ROBERTSON + MARKS

STAGE 1 SHEPHERDS BAY RESIDENTIAL

ACCESS REVIEW

11 December 2011

Drawing Title : UPPER BASEMENT PLAN

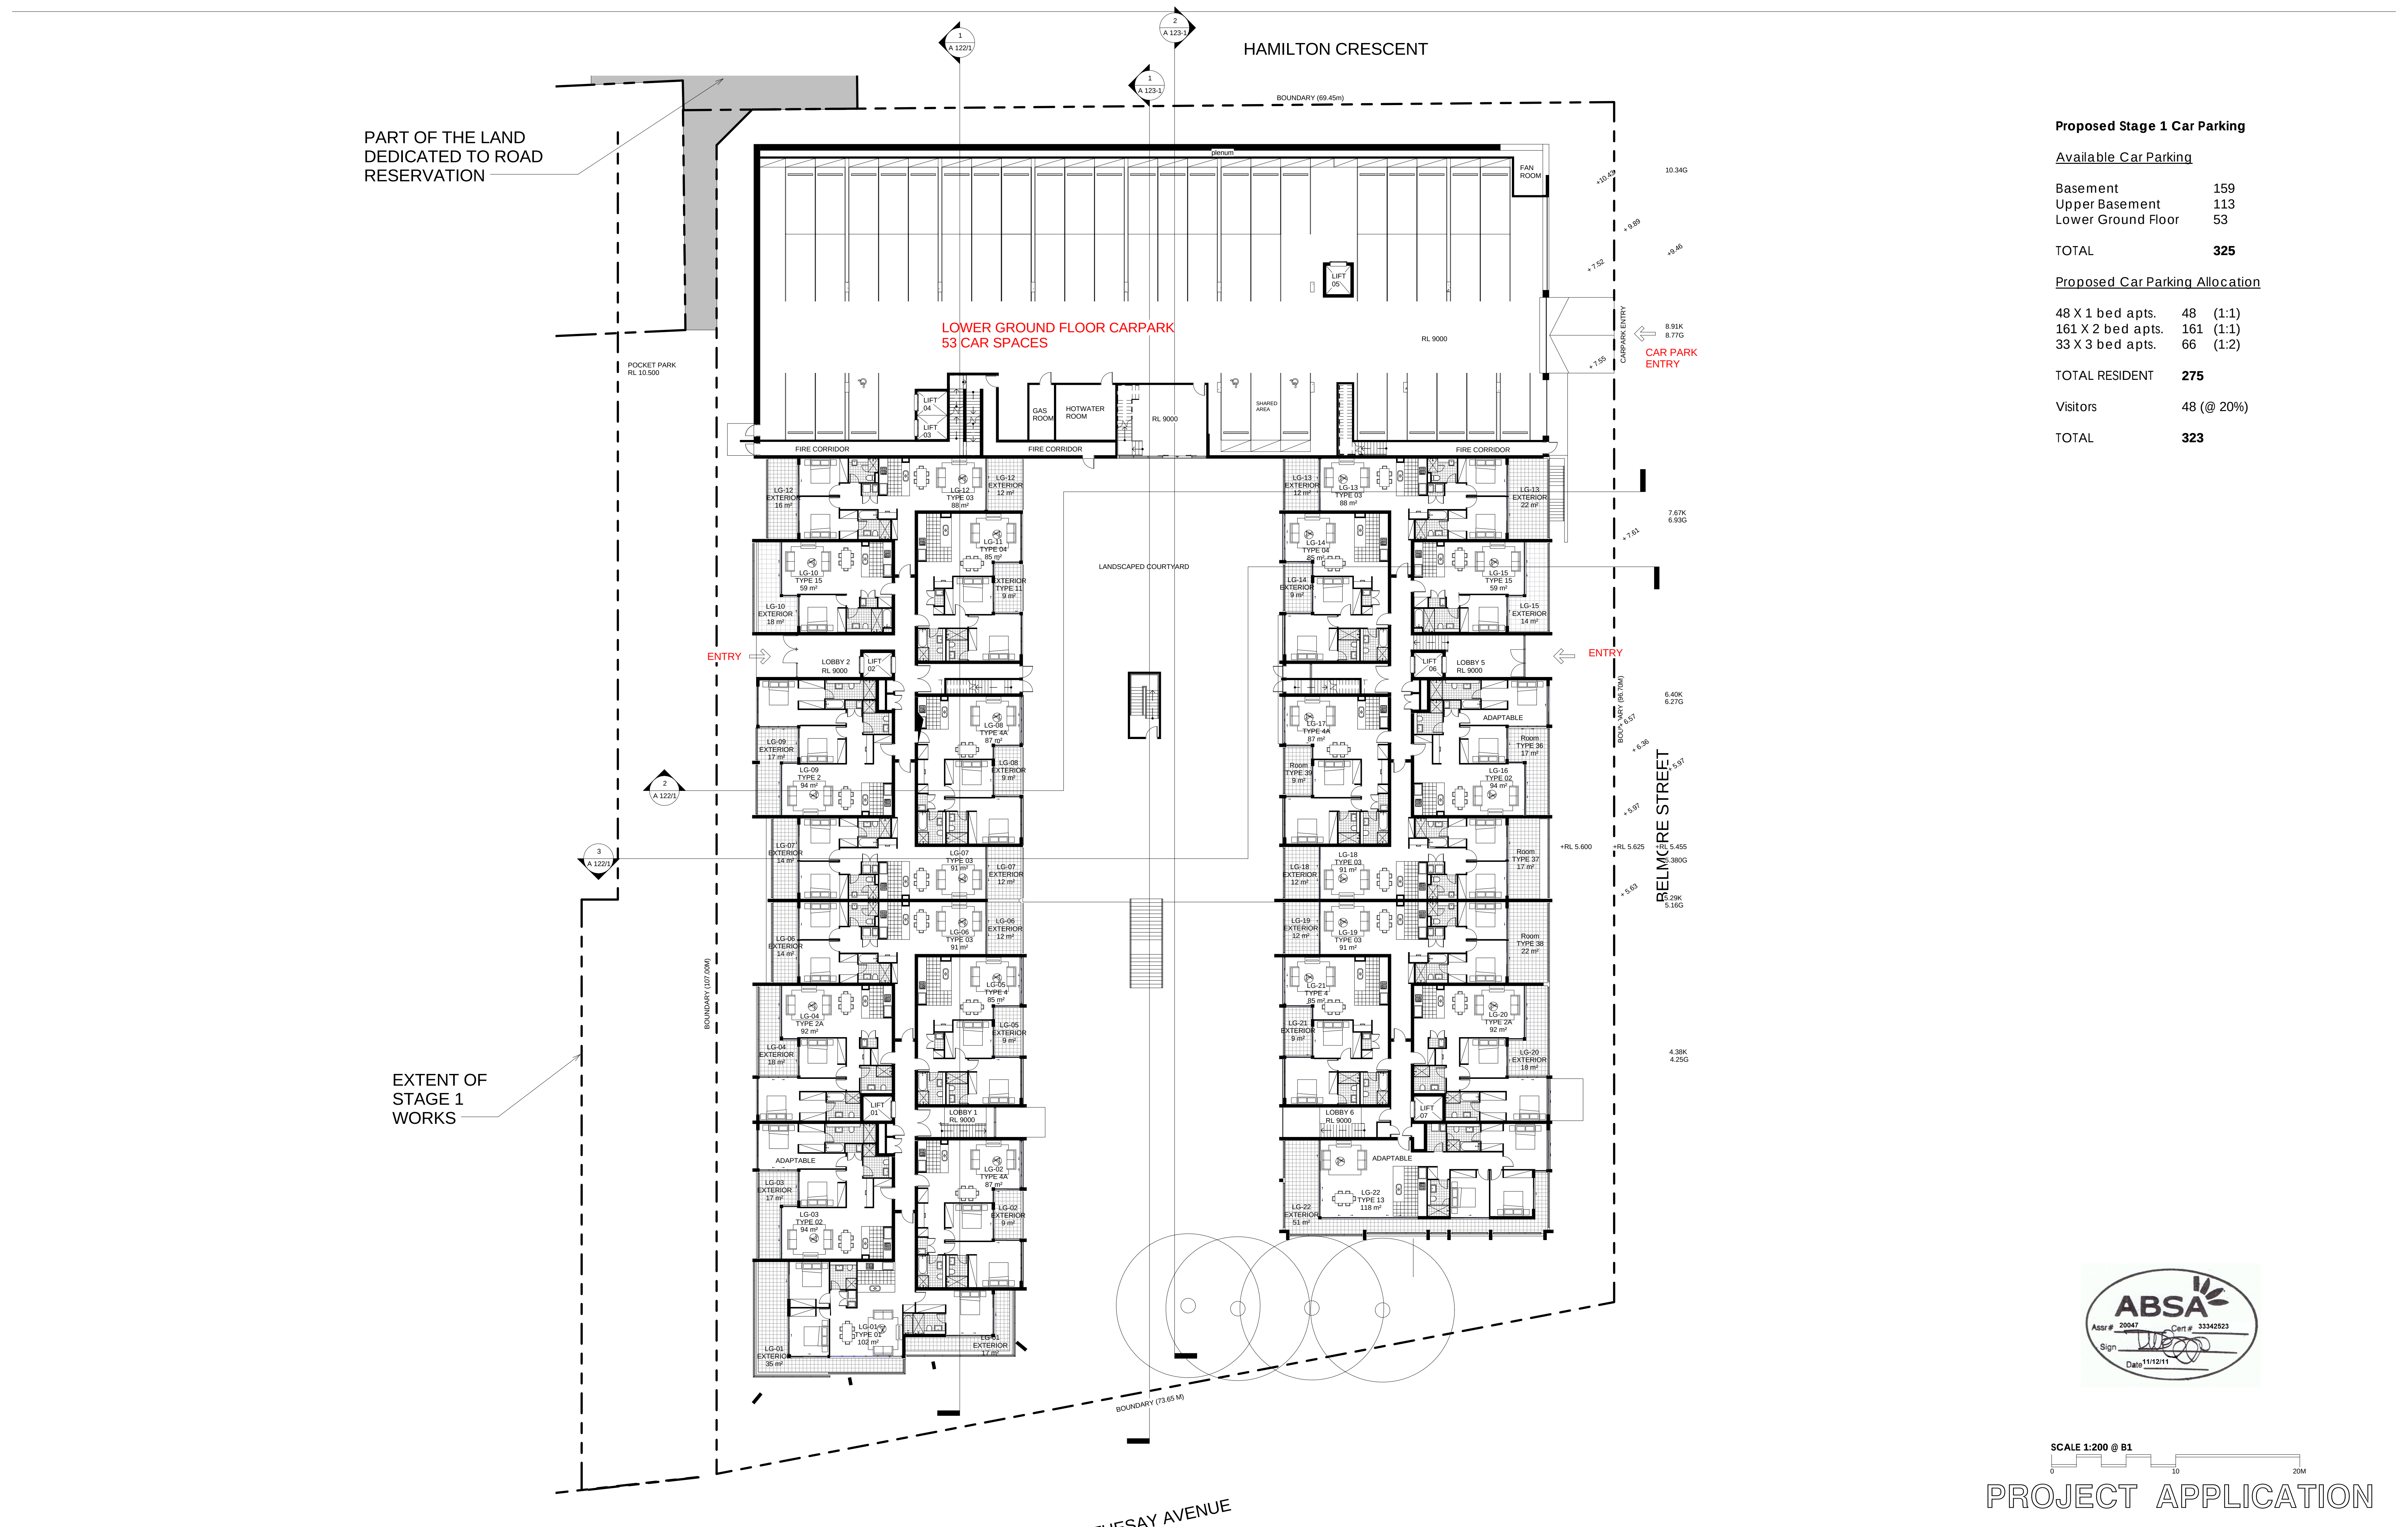
There are 3 separate levels of car parks with adaptable parking bays located across all levels.

There are 31 adaptable unit parking bays provided with a width of 2.4 metres with 2.4 metres, in accordance with AS2890.6. There are 16 adaptable unit car bays on basement level, 12 adaptable unit car bays on upper basement and 3 adaptable unit car bays on lower ground floor.

In general, the adaptable unit car bays are not appropriately distributed across the basement levels for lobby 1, lobby 3 and lobby 6. It is these lobbies that accommodate the adaptable unit. Modifications are required.

- (i) Whilst there are suitable number of adaptable unit car bays, these car bays need to be repositioned adjacent the relevant lift so that they correlate with relevant adaptable unit
- (ii) Each adaptable unit car park requires a height clearance of 2.5 metres.
- (iii) The approach to each adaptable car parking bay should not have vertical clearance of less than 2200mm.

Building Name : STAGE 1 PROJECT APPLICATION (MP 09_0219)
Drawing Title : GROUND FLOOR PLAN
Scale : 1 : 200 @ B1
Date : 07-JAN-2011
Job Number : 10068
Drawn : A
Drawing Number
A 104/1
Authorised by : IF

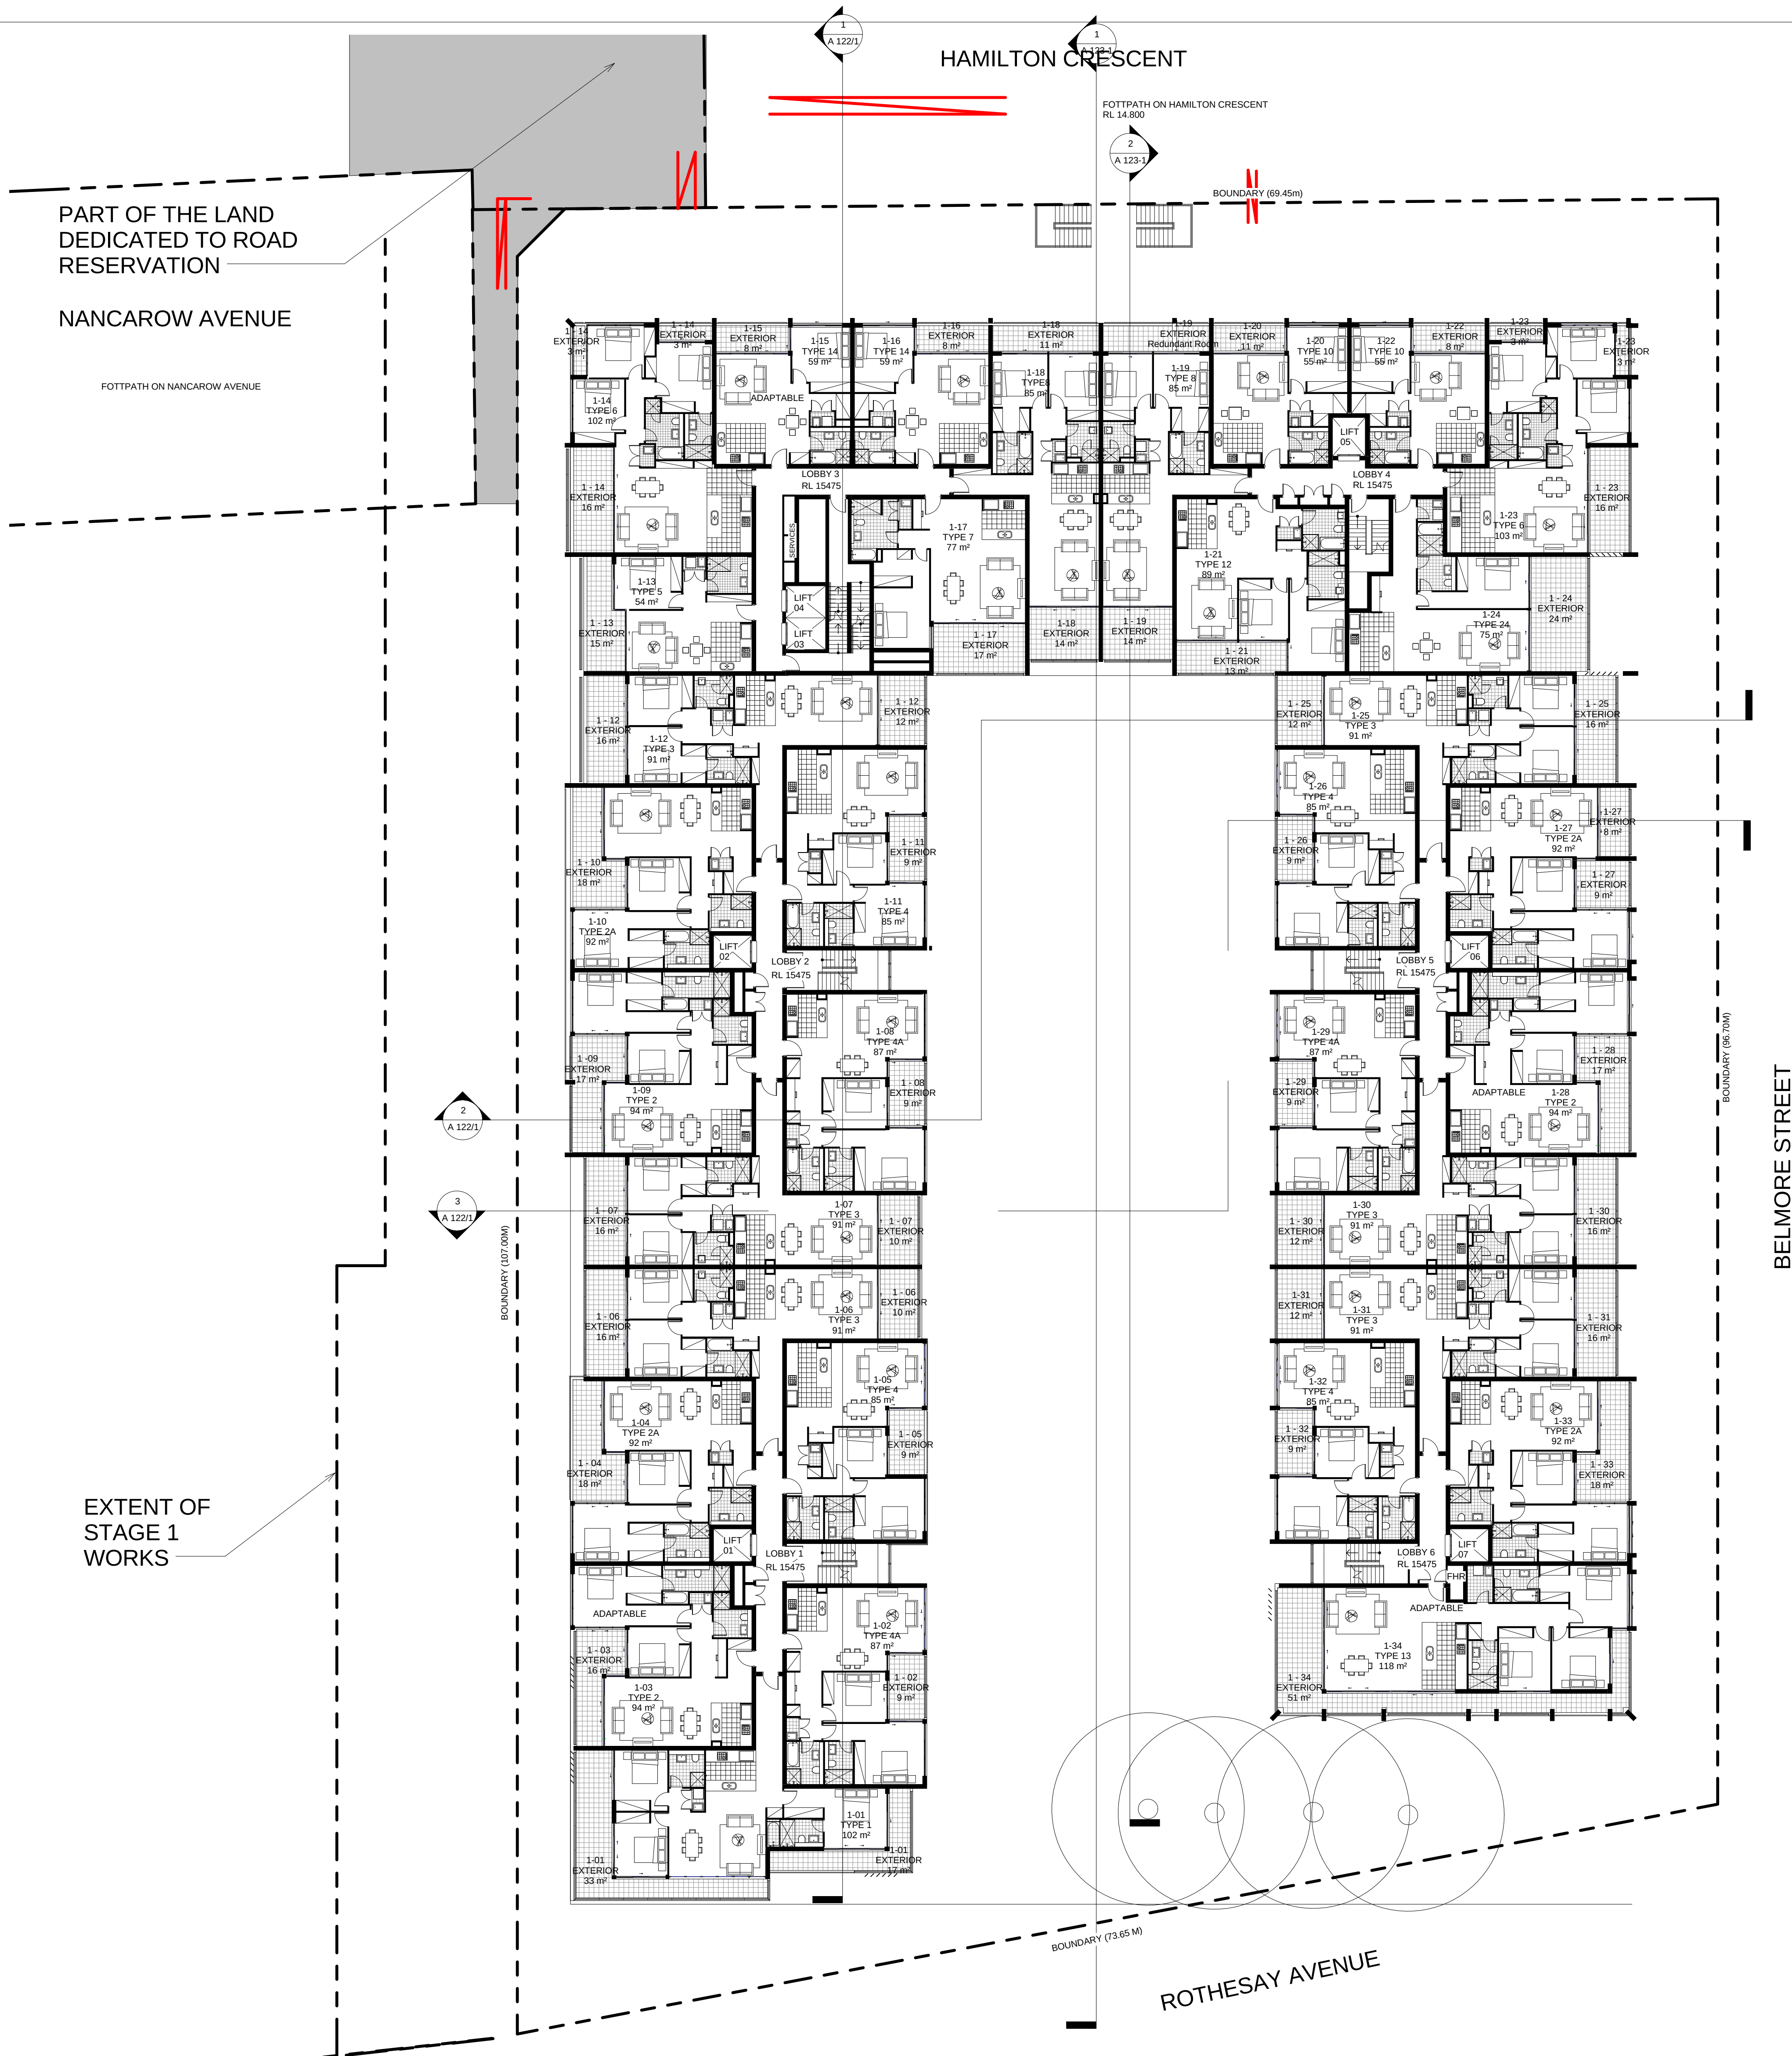
The ground floor Hamilton Crescent lobby is accessible via the pedestrian footpath. The path of travel appears to be on grade compliant with AS1428.1. There is direct access into lobbies 3 and 4 from the entry doors.

The entry doors have an 850mm clear width (900mm door leaf) and appropriate clearances and circulation compliant with AS1428.1 and Ryde Access DCP. There is appropriate circulation areas in front of the passenger lift appropriate for a person in a wheelchair.

- (i) The doors into lobbies 3 & 4 require 530mm latch side clearance in accordance with AS1428.1.

However there are issues under DDA Premises Standards when there are no sightlines from the lift lobby down a corridor that turns from the lift lobby, in particular lobby 3 on ground, level 1 and level 2.

- (i) The corridor doors into lobbies 3 & 4 require 530mm latch side clearance in accordance with AS1428.1.
- (ii) An area of 2000mm x 1800mm is required the corridor 90 degree turn of lobby 3 ground, level 1 and level 2 in accordance with DDA Premises Standards
